Our ref: DOC21/1019642-16

Your ref: SSD-15950052

Major Projects – New Request for Advice - Eraring Battery Energy Storage System (SSD-15950052) (Lake Macquarie City)

Biodiversity Conservation Division (BCD) has reviewed the '*Biodiversity Development Assessment Report for Battery Energy Storage System*' (BDAR) dated October 2021 and its Appendices.

FIGURE 1.2
Development Footprint

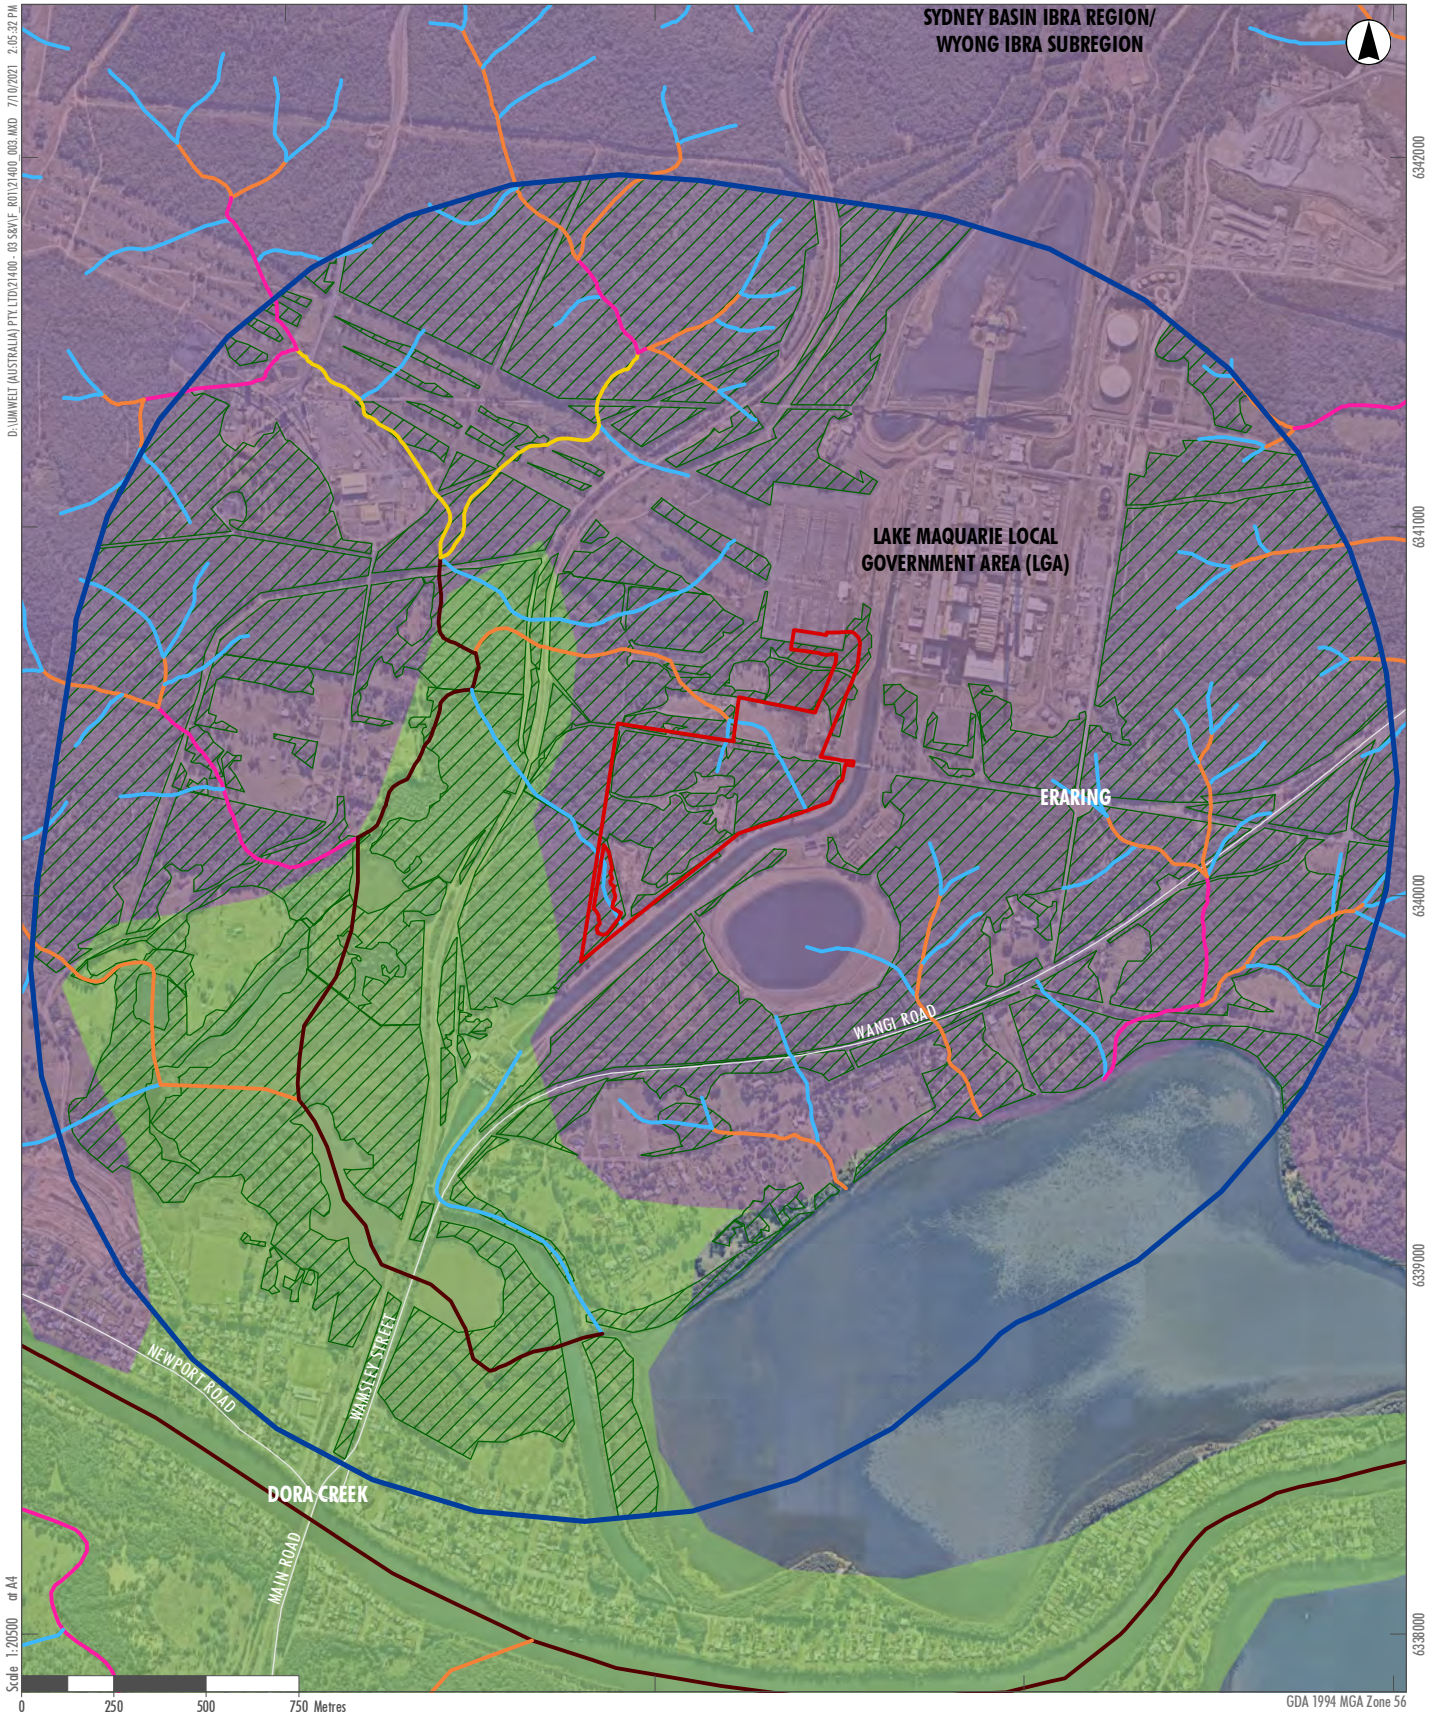
Although BCD acknowledges that historic imagery from August 2010 (as per Figure 1.4 – Development footprint in March 2020) clearly shows the area that corresponds to Vegetation Zone 3 is devoid of vegetation, it does not demonstrate that it has regrown from a replanting program. Analysis of the subject area under Near Map (accessed December 2021; <https://www.nearmap.com/au/en>) shows that the vegetation is more likely to have regrown back over the last 10 years from small patches of suckering (on the edges and centrally) or natural regeneration of Swamp Oak which has radiated out from them across the site, along with likely wind-blown or natural regeneration of shrub and groundcover species.

The imagery does not show a uniform regeneration pattern over the 10 year period since the clearing (which would lend its support to a replanting program), but it is a more sporadic, patchy pattern of regeneration over the years. Nor is there any indication of a cultivation / sowing pattern to the subject site, except for a very small area of what appears to be cultivation on the 26 April 2013 image and regeneration of vegetation in rows in the subsequent imagery. However, this covers less than 5% of the originally cleared area and appears to be a mixture of low shrubs and groundcover and appears to have disappeared by 2018.

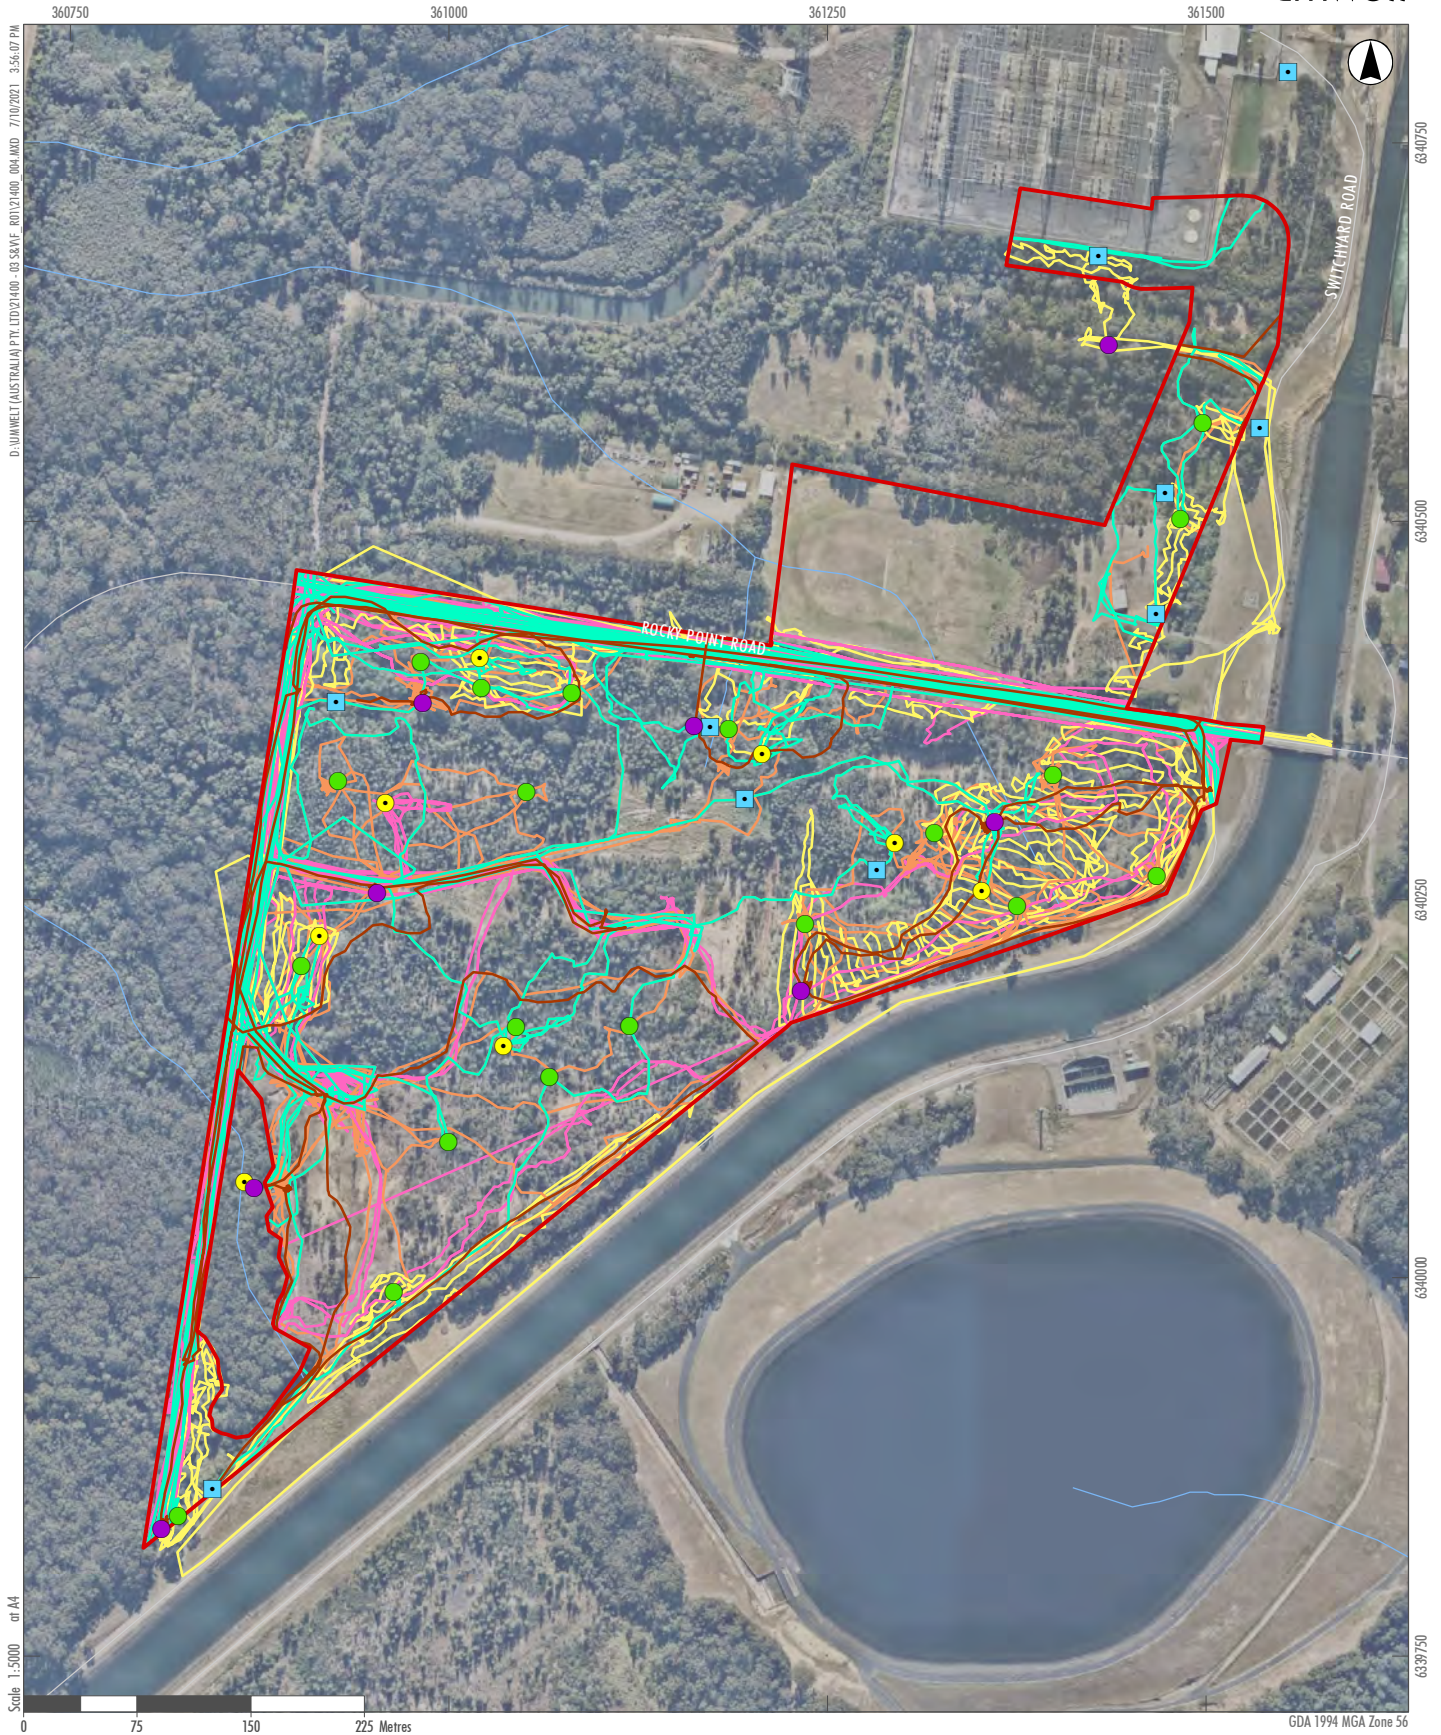
5. Identify the plots on the Plant Community Types and Development Footprint figure (Figure 3.1 in the BDAR)

Figure 3.1 in the BDAR shows the plots overlaying the PCTs within the subject site. However, the plots are not numbered with their unique identifier (e.g. Plot No. 3), thus making it difficult to determine which plots equate to which PCT. This is problematic when trying to assess or interpret the cover / abundance data and species present per plot in Appendix 4 – Flora Species List, as you cannot accurately determine which species was found in which PCT.

BCD recommends the accredited assessor update Figure 3.1 in the BDAR to show the plots with their unique plot identifier against the Plant Community Types.
